CITY OF ALBUQUERQUE

Re: Fire Station No. 2, 1301 Gibson Blvd. SE
Request for Permanent C.O. - Approved
Engineer's Stamp dated: 1-03-2011 (L16/D060)
Certification dated: 12-13-12 15

DRAINAGE AND TRANSPORTATION INFORMATION SHEET
(Rev. 1-28-03)

PROJECT TITLE: Fire Station No. 2 ZONE MAP/DRG. FILE #: L-15
DRB#: 11DRB-70327 EPC#: _____ WORK ORDER#: _____

CITY OF ALBUQUERQUE FIRE STATION NO. 2

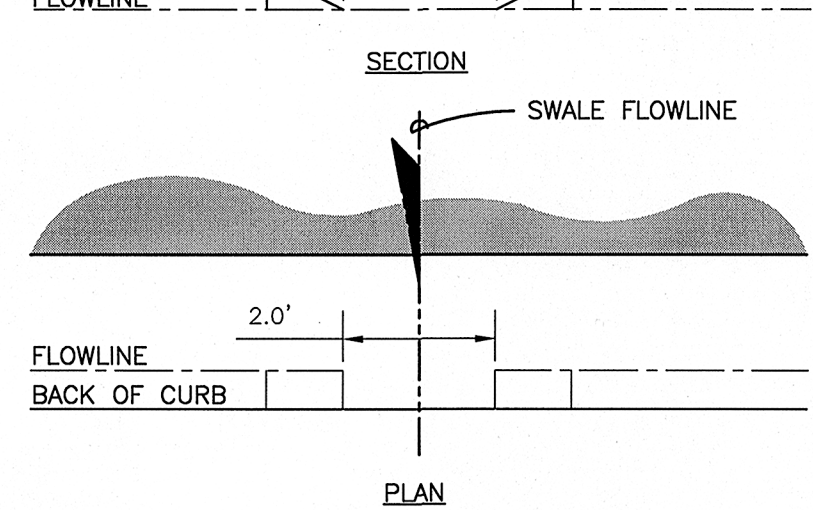
- The retention pond and swale leading to it, as part of the Site Plan approval, is required to be on this Grading Plan. If the facility in the easement is constructed during the construction of this site, a new Grading Plan can be submitted showing the facility in the easement and therefore a pond would not be necessary.

- Provide flow and volume calculations, a project narrative and basins.
- Show the flows leaving the site as was shown in the submittal for Site Plan approval.

- Provide widths of sidewalk culverts in the ROW, specify to be built per COA STD DWG 2236 and provide SO 19 Notes.
- Provide spot elevations and a build note for the curb cuts.

- Provide a detail for the swales leading to the sidewalk culverts.
- Does the access drive transition to inverted crown at the west end? It is not clear how runoff will enter the swale. In addition, it appears there is curbing proposed at the west end.

- Provide direction of roof flows.
- Why is the BW grade at the north end of the retaining wall 5047.0, when there is a proposed 5054 contour in this location?

- Additional spot elevations should be provided; in the corners of the parking areas, in the dumpster enclosure, upstream of sidewalk culverts, flow line in Alumni Dr. at proposed drive entrances.
